Rezoning Transportation Analysis

Petition Number: #2022-170

Revision Log:

Date	Description
02-22-23	First Review (TM)
03-23-23	Second Review (TM)

REZONING PETITION #2022-170
SCHEMATIC SITE PLAN

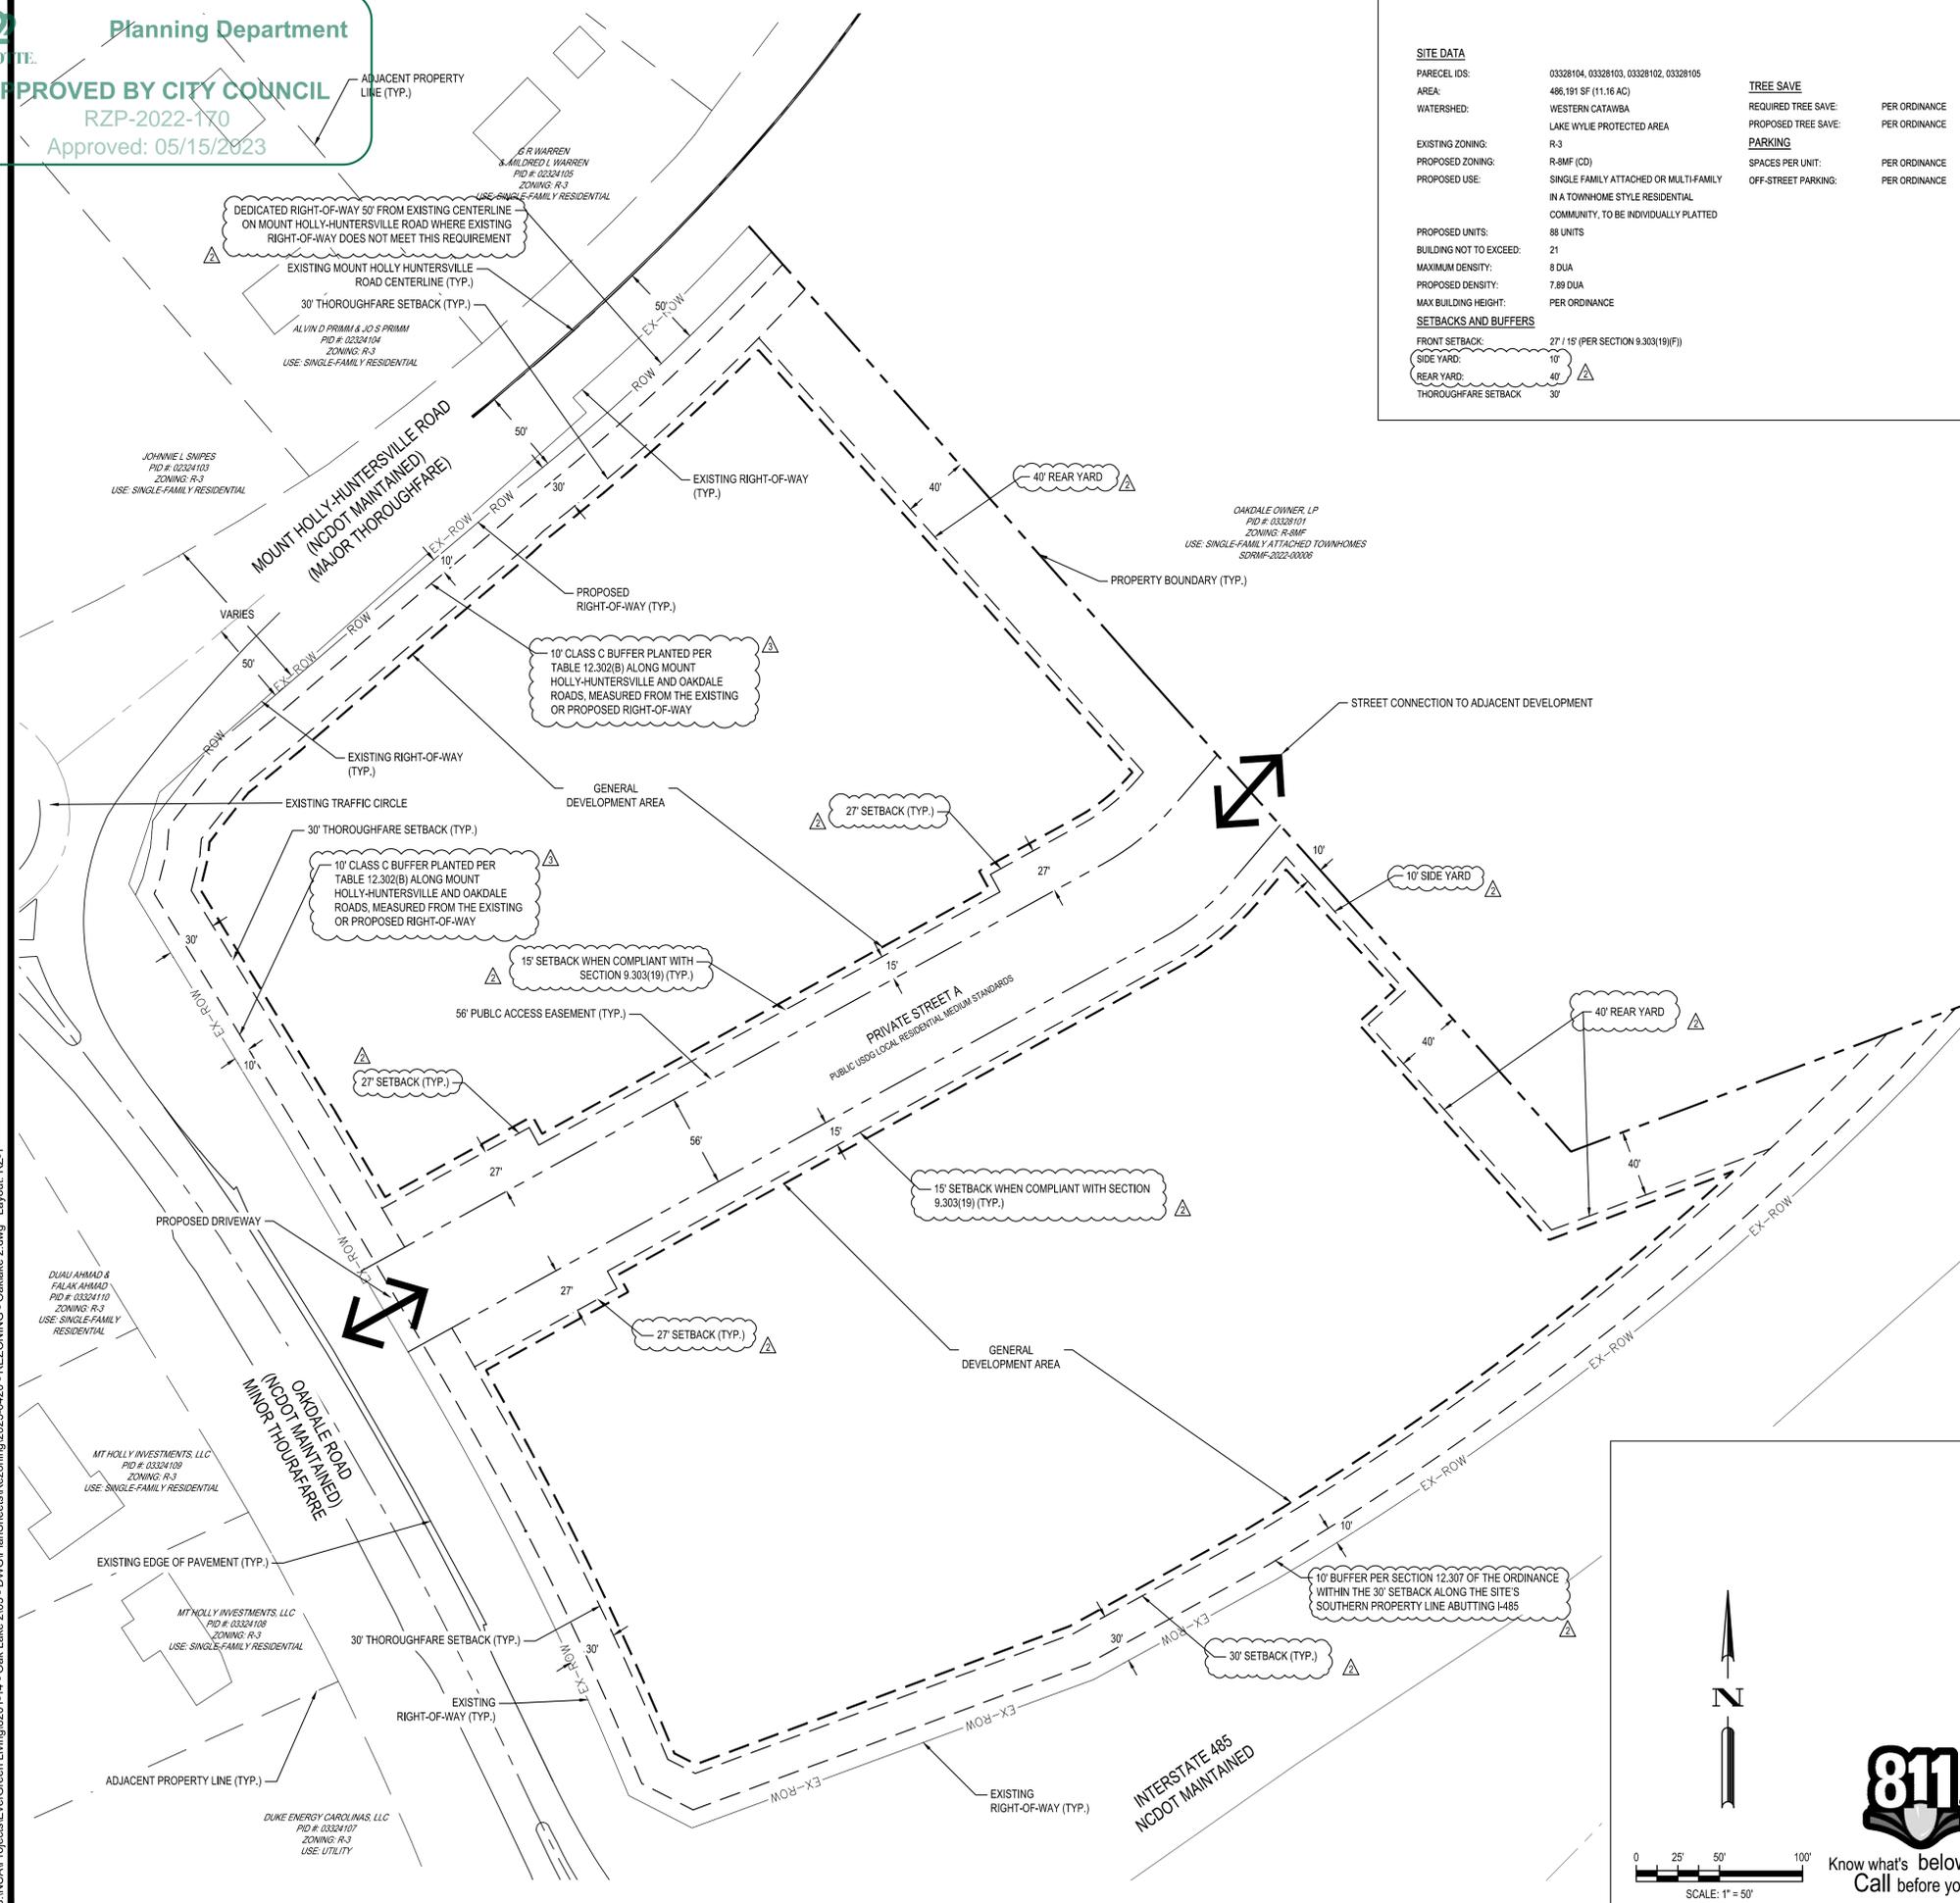
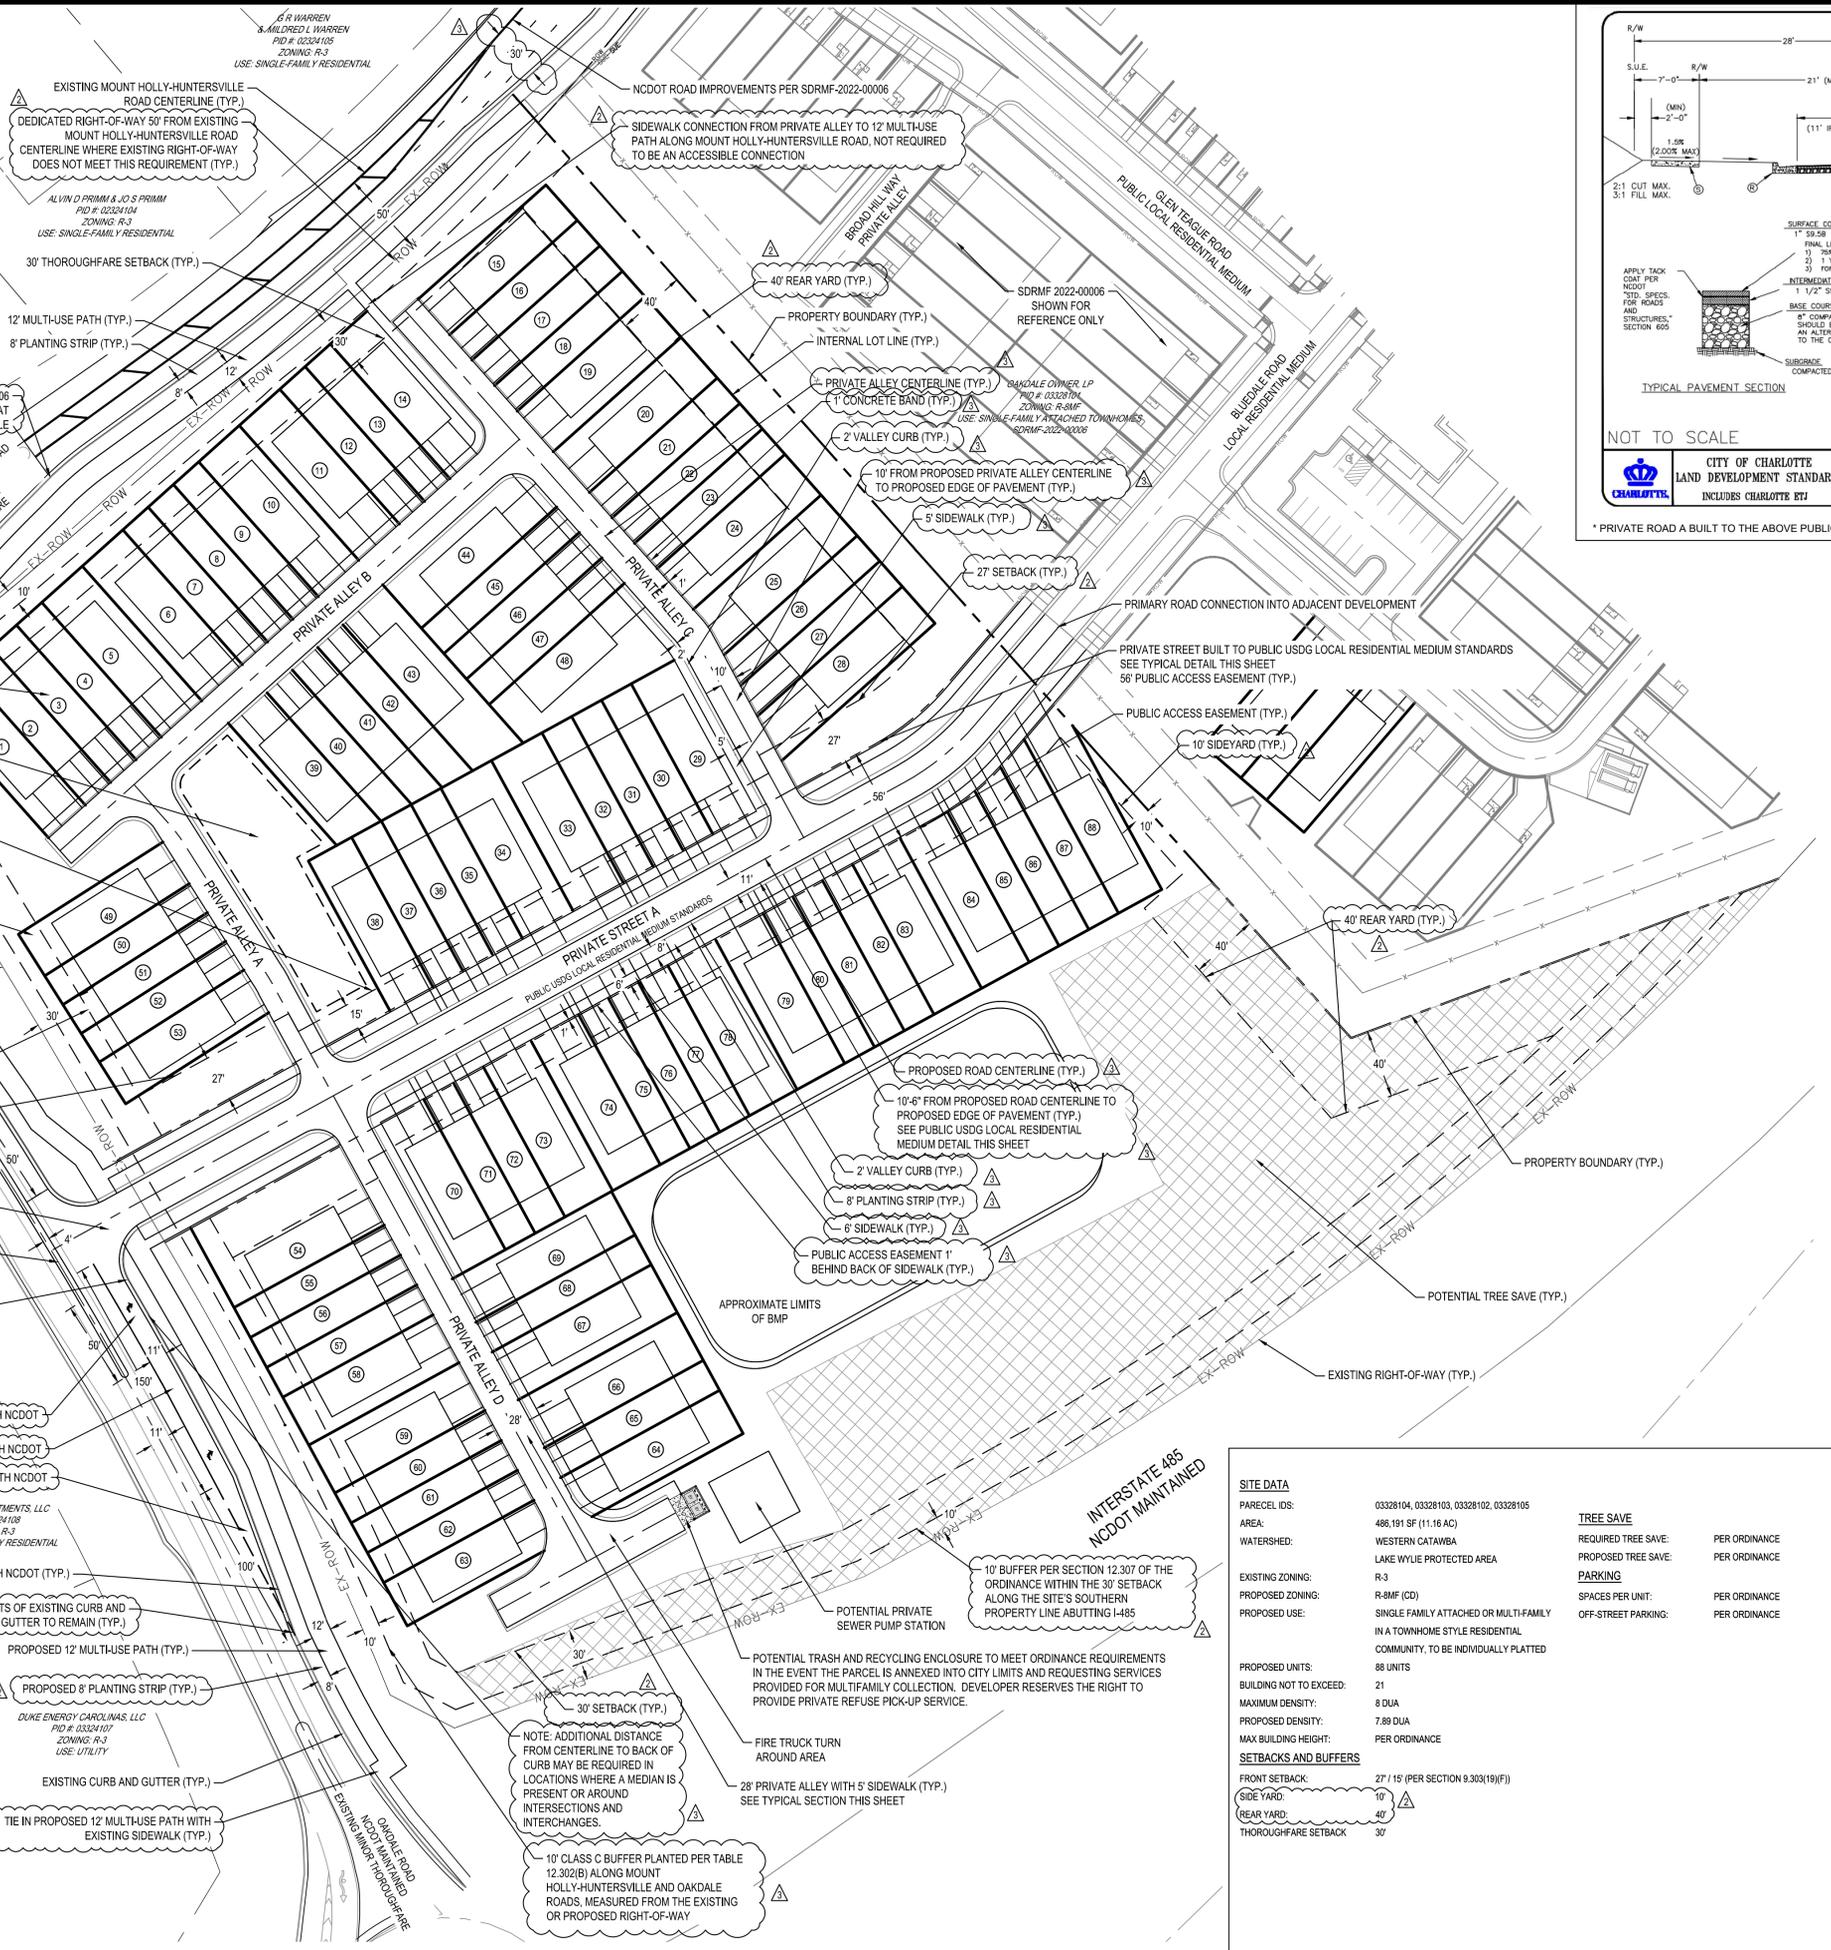
- Mt Holly-Huntersville Road:** Location of curb and gutter to be moved to 30-feet feet from roadway centerline to accommodate the Charlotte Streets Map with a roadway typical section of 4+ Avenue, Shared Use Path.
- ~~**Oakdale Drive:** Location of curb and gutter to be moved to 19 feet from the roadway centerline to accommodate the Charlotte Streets Map with a roadway typical section of 2+ Avenue, Shared Use Path.~~

Label and dimension the curb and gutter from the centerline for each road on the site plan.

- Outstanding Comment from 02-22-23:** Revise site plan and conditional note(s) to commit to Private Road A to be a public roadway.

8. **Outstanding Comment from 02-22-23:** Revise site plan by dimensioning and labeling the internal street infrastructure including curb line, sidewalk, planting strip and Right of way.

13. **New Comment 03-23-23:** Remove driveways from CDOT 50'x50' sight triangles areas connecting to Street A.
